Yorkshire Green Energy Enablement (GREEN) Project

**Document 8.25.1 Applicant's Response to Examining Authority's
Second Written Questions (ExQ2)**

Planning Inspectorate Reference: EN020024

National Grid Drawing Reference
 DCO_D5/ExQ2/Q4.3.1_1

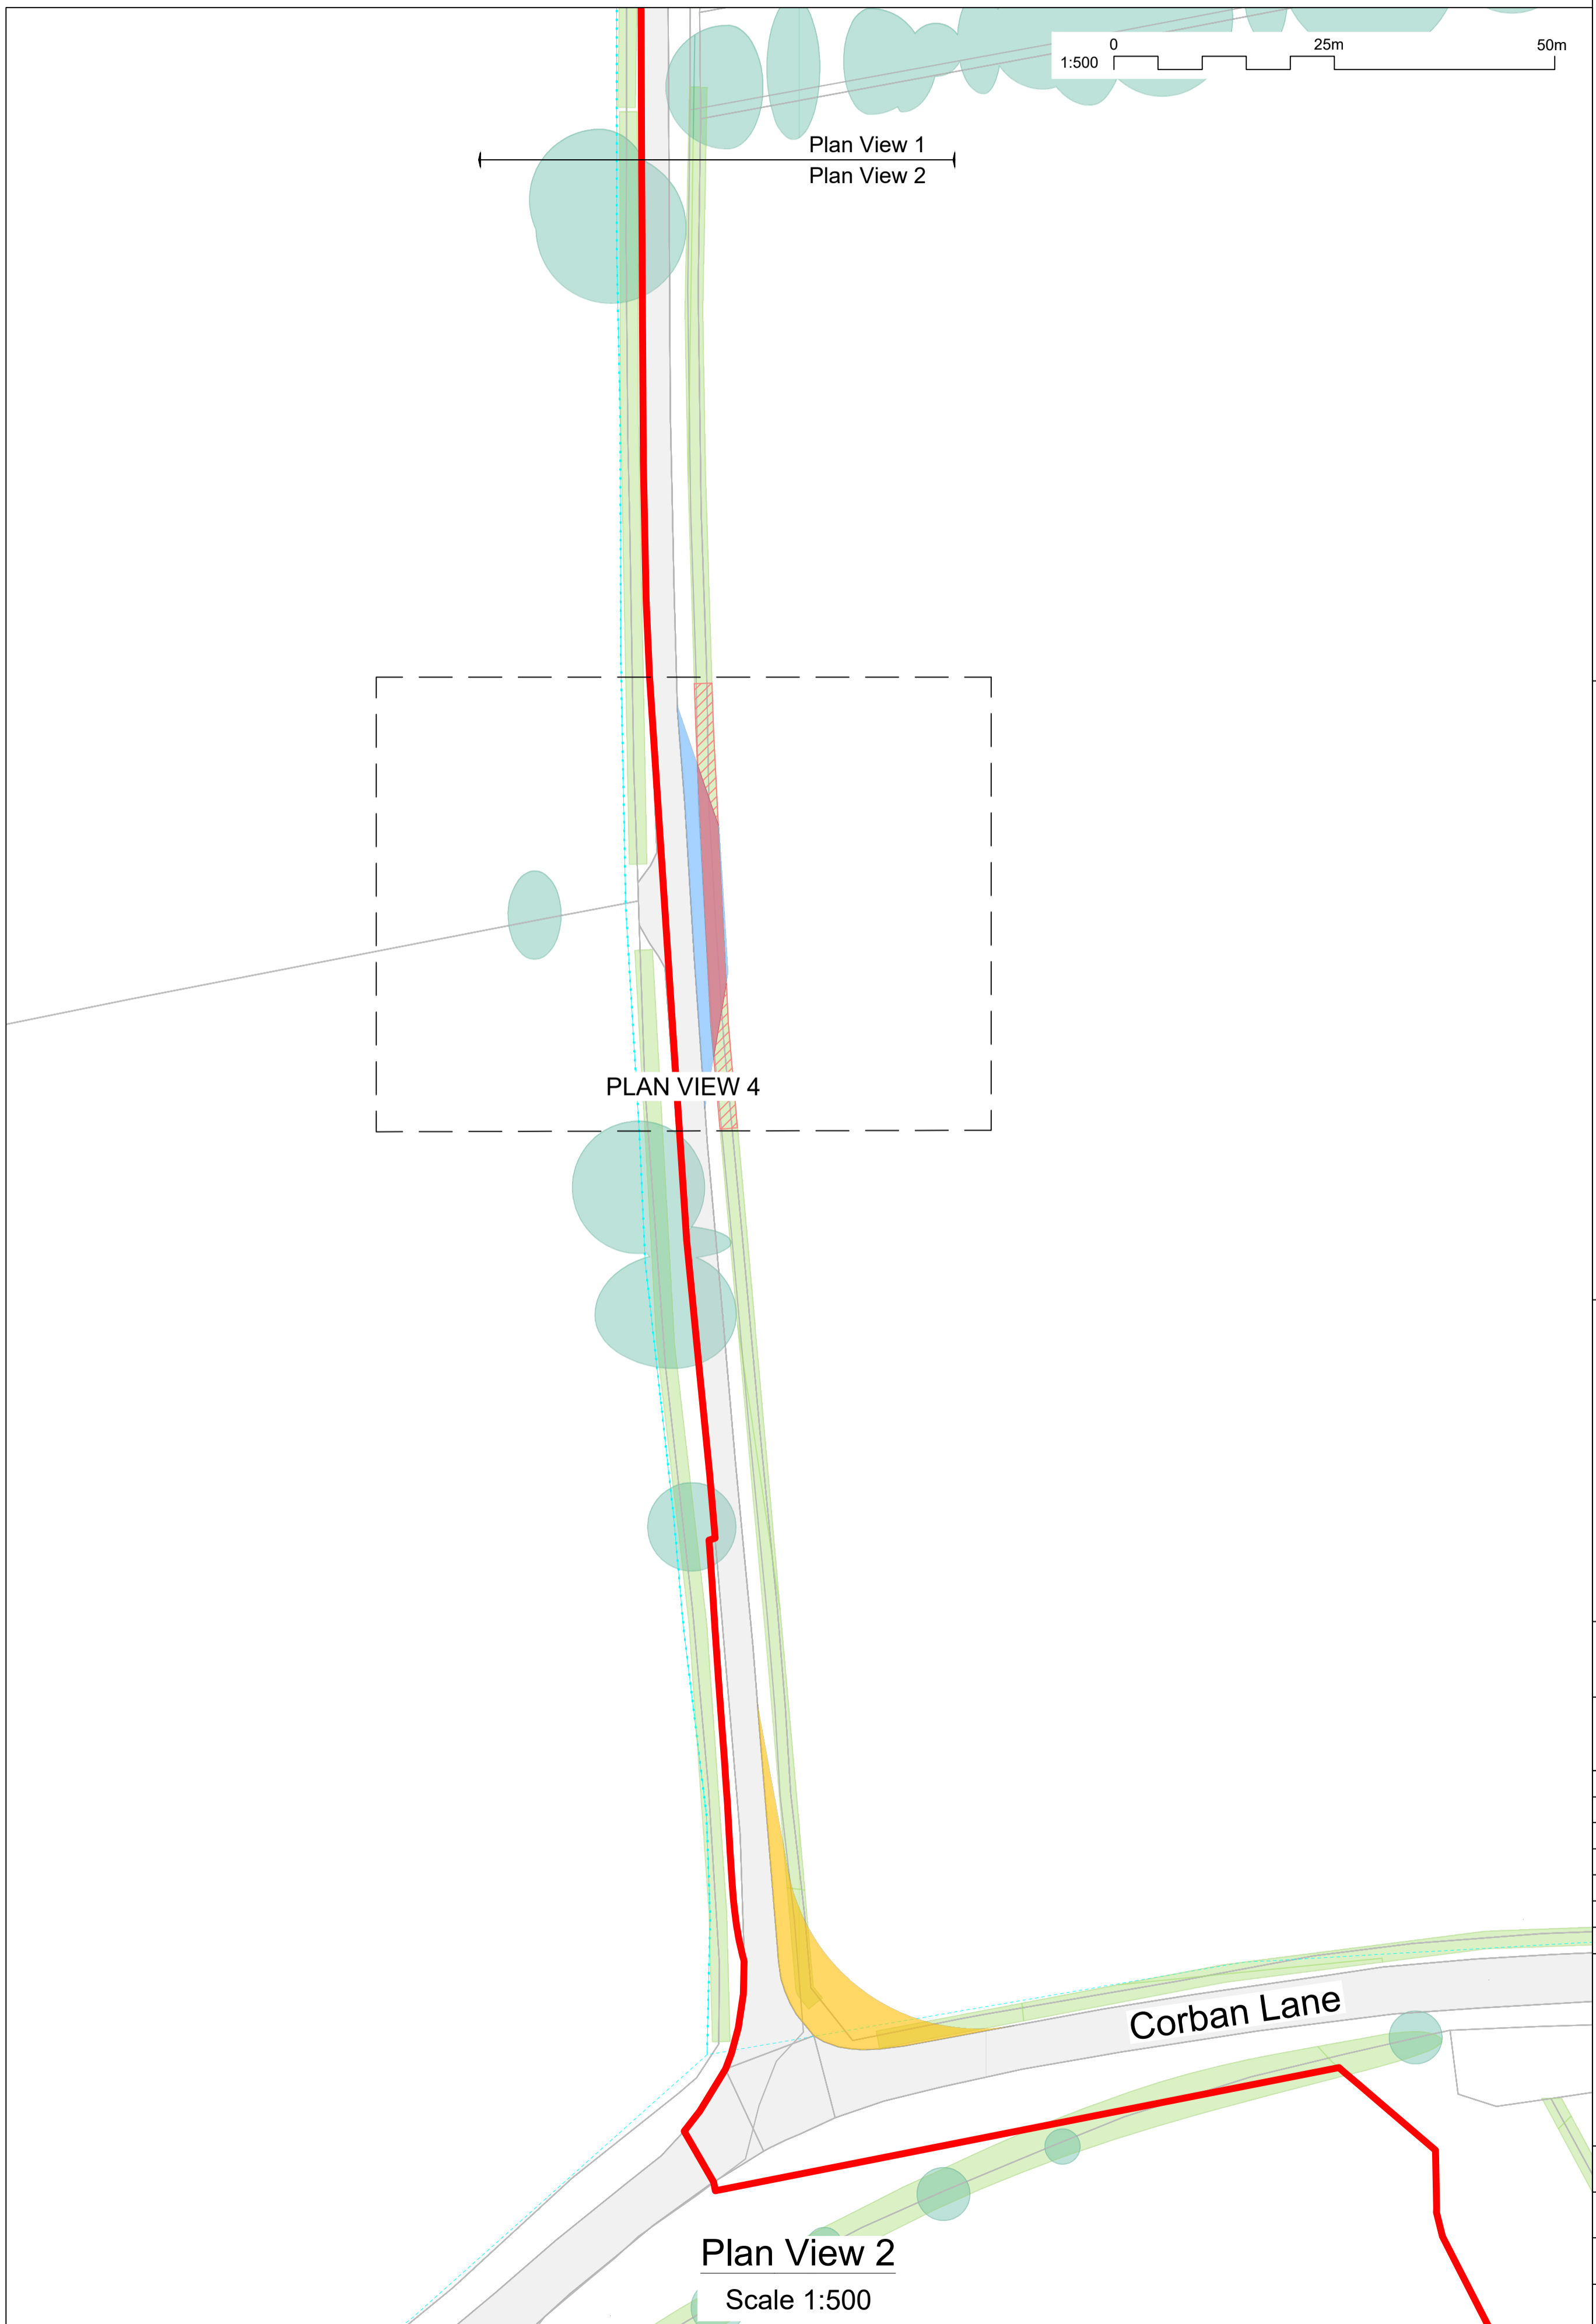
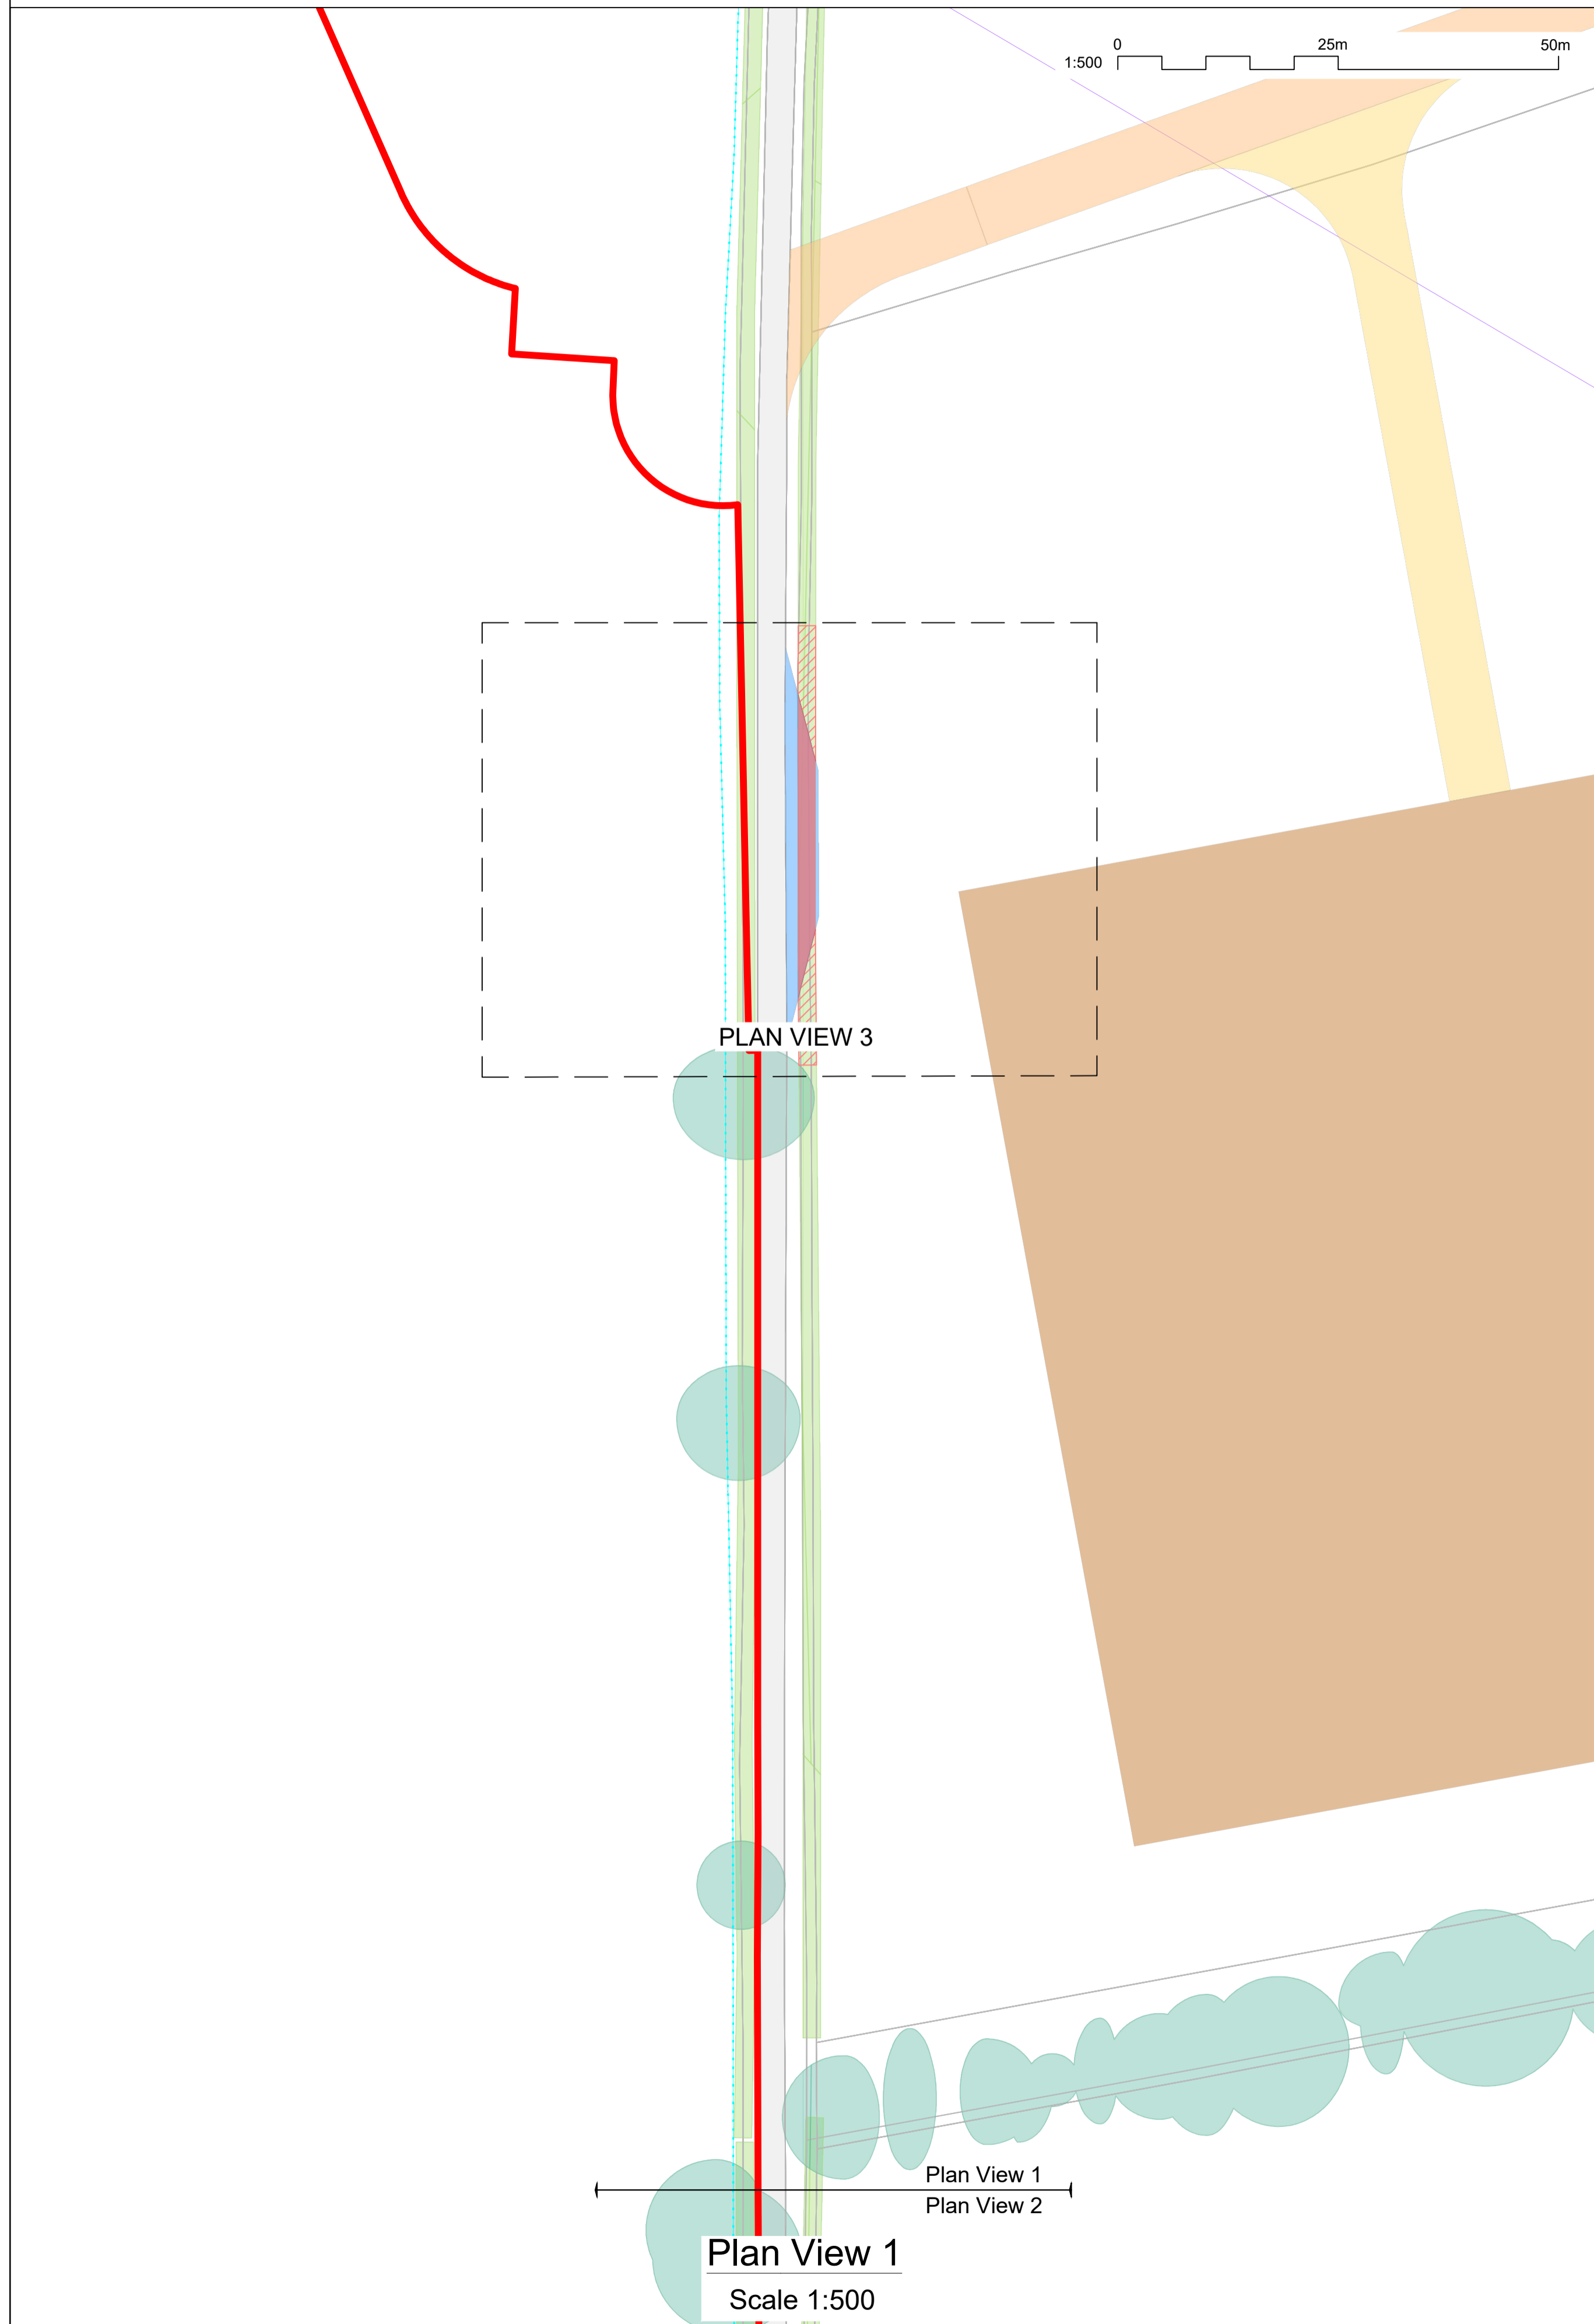
Ref No.	Respondent:	Question:
4.3	4.3 Individuals’ objections, issues and voluntary agreements	
Q4.3.1	The Applicant	<p>Access to Shipton Cable Sealing End Compounds Further to the alternative access suggested by the Rab family’s Land Agent to the cable sealing end compound [REP4-030], point 5 and the Applicant’s CAH1 action 2 [REP4-027]:</p> <ol style="list-style-type: none"> a) Provide an update on discussions with Mr Stephenson and the Rab family, which should include working with the Rab family and/ or their Land Agent to establish the feasibility of the alternative access proposed, together with relevant plans identifying the Order limits. b) If the technical feasibility of such an alternative access would require additional land outside of the Order limits, set out the implications of this. <p>Applicant’s Response:</p> <ol style="list-style-type: none"> a) National Grid issued a letter setting out the proposed change to the landowner, occupier and a copy to the agent on the 19 June 2023 with accompanying plans. This letter sought written agreement on the proposed access change. Subsequently National Grid met with the landowner, occupier and agent on 23 June 2023 and 30 June. National Grid has received consent to the proposed change from both the landowner and occupier on 03 July 2023. This is further detailed in Change Application: Report on Proposed Changes (Document 9.1) submitted at Deadline 5. b) The proposed alternative access can be accommodated within the existing order limits, and no change to the order limits is required.
